**RE: Presbyterian San Pedro FSED
6400 Paseo Del Norte NE
Grading and Drainage Plan
Engineer's Stamp Date: 06/26/18
Hydrology File: D18D056**

Based upon the information provided in your submittal received 06/27/2018, the Grading and Drainage Plan **is not** approved for Building Permit and Grading Permit. The following comments need to be addressed for approval of the above referenced project:

C-100

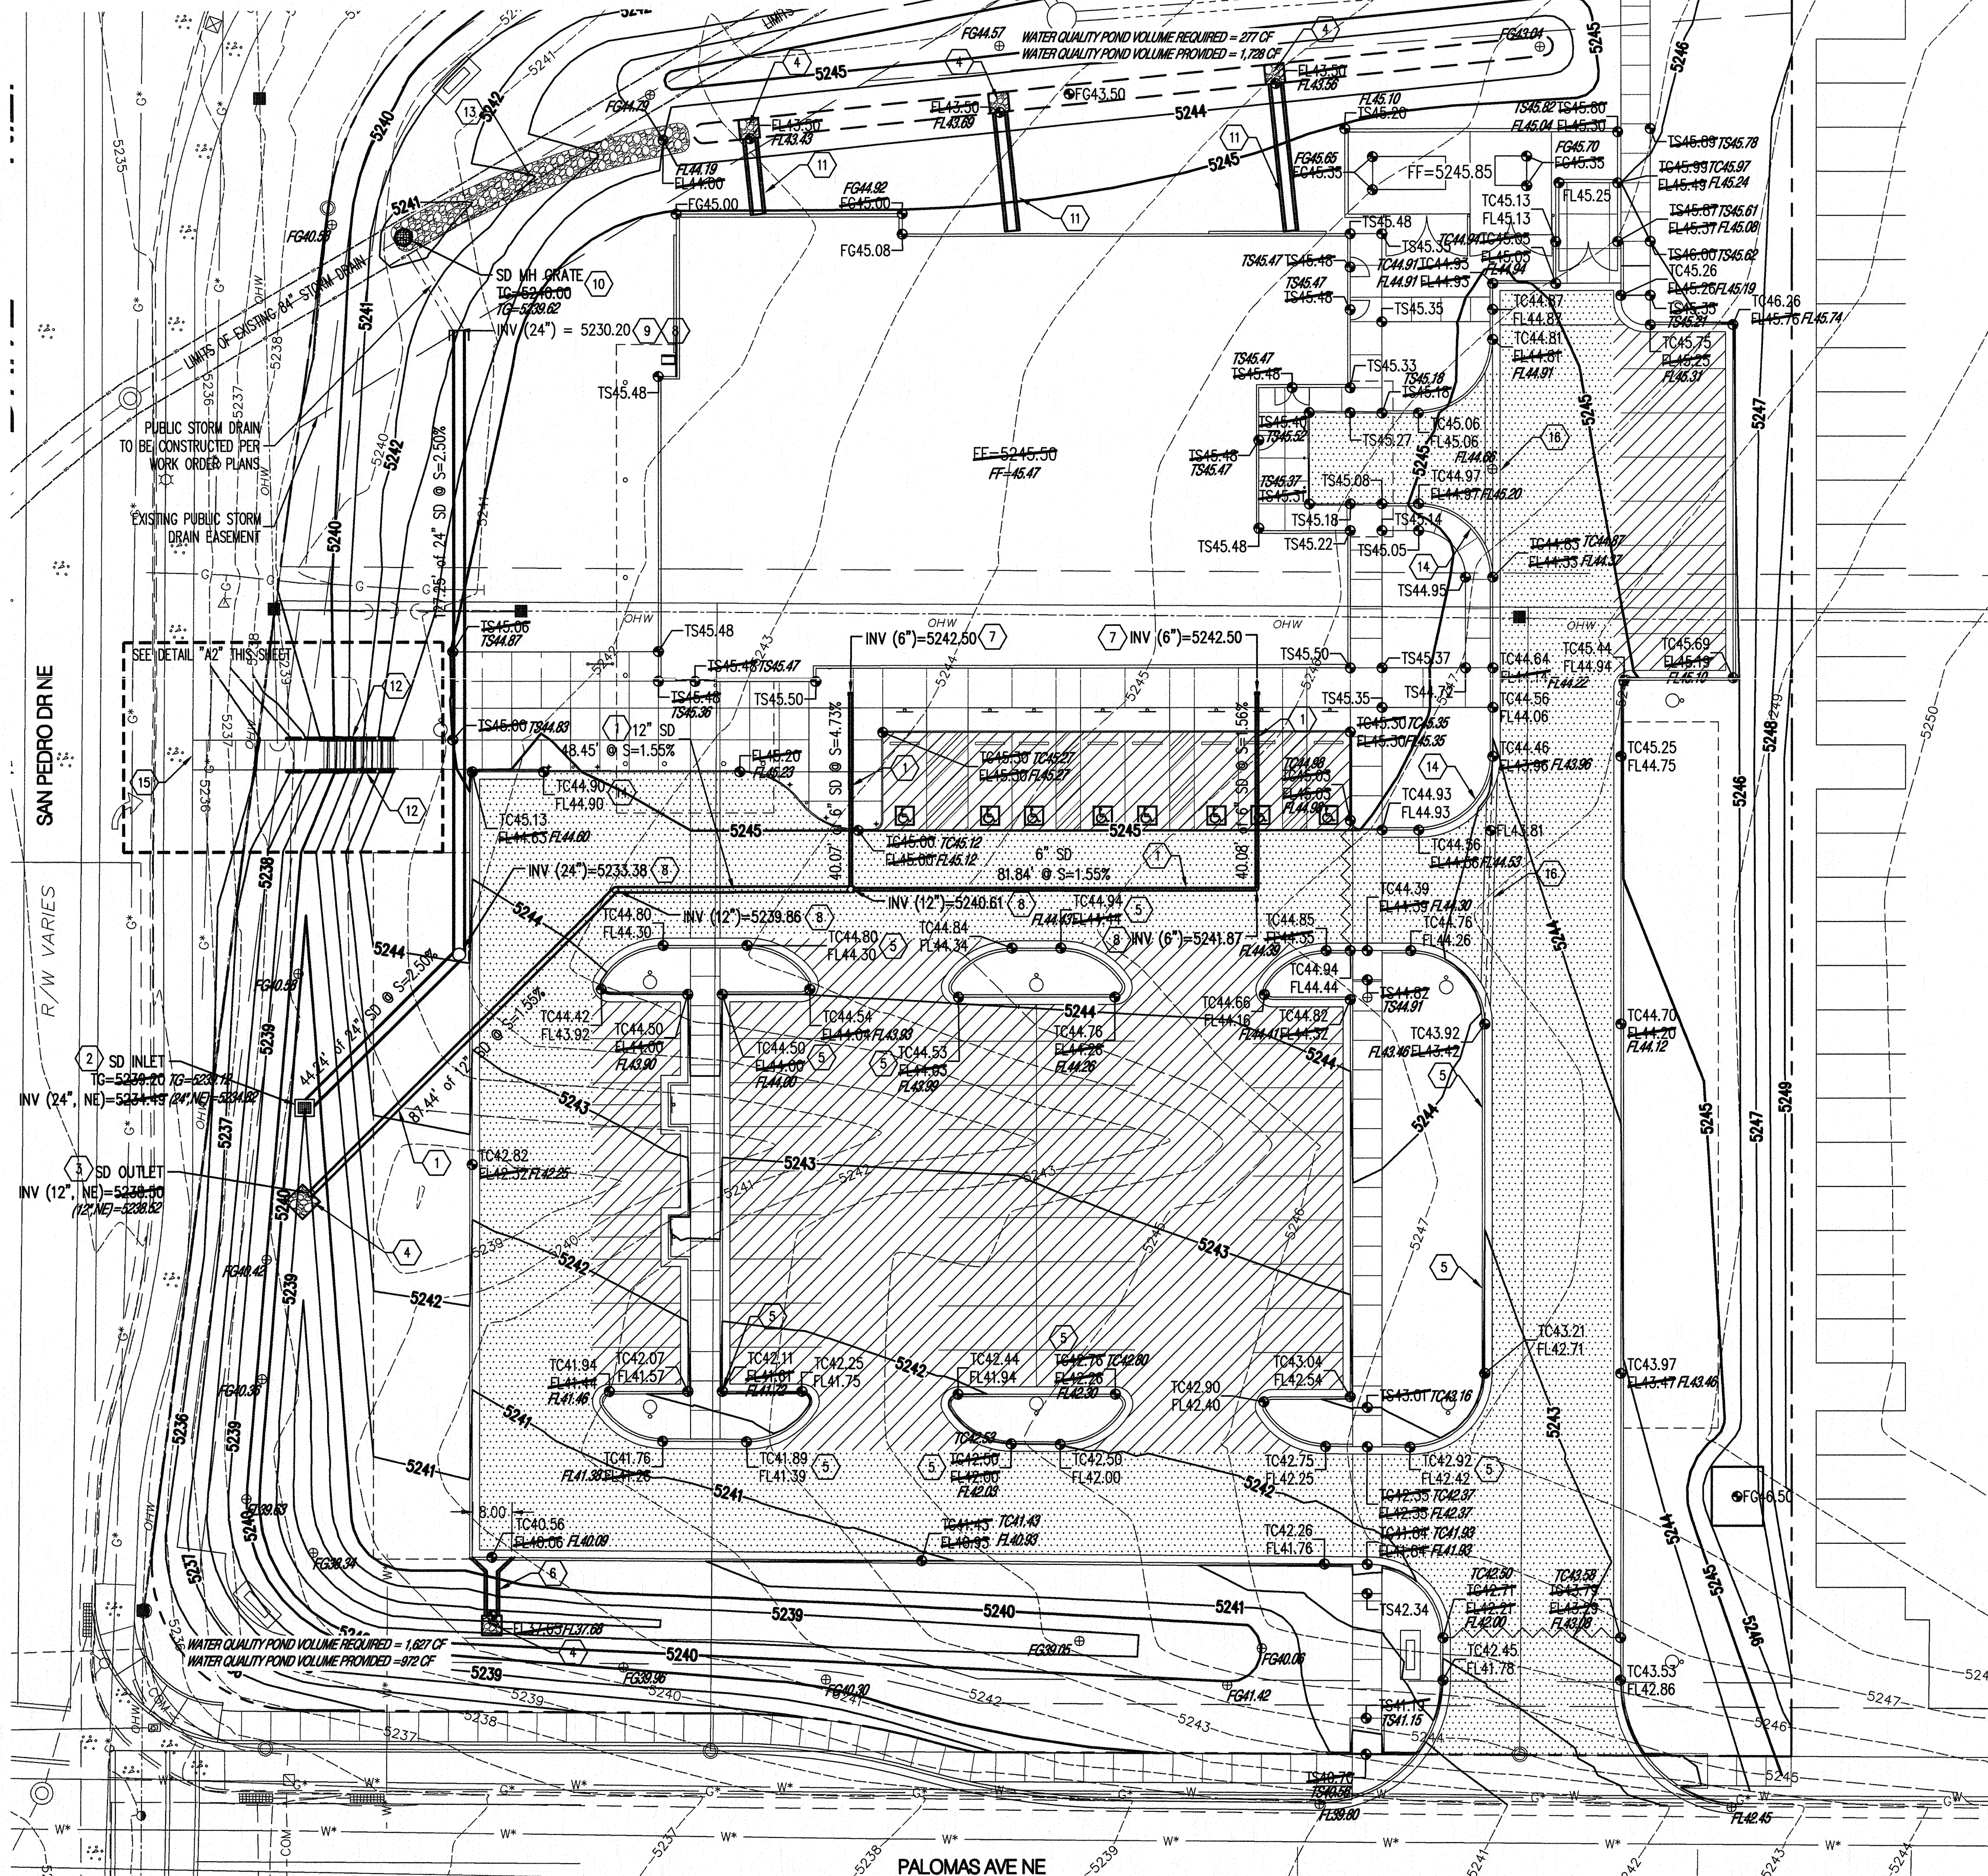
3. Please provide the benchmark information for the survey contour information provided.
4. Please provide the weir calculations for the curb cuts and concrete rundown.

5. Please label the storm sewer within the existing drainage easement as "public storm drain to be constructed in the work order plans".
6. How is the bend connection from the private 24" HDPE to the public 24" storm drain being handled? If needed please provide a detail.

7. Is inlet IN2 part of the work order since it is within the existing drainage easement? Please provide a detail of how you are installing this inlet over the existing 84" storm drain. Is this going to be a manhole with an inlet top?
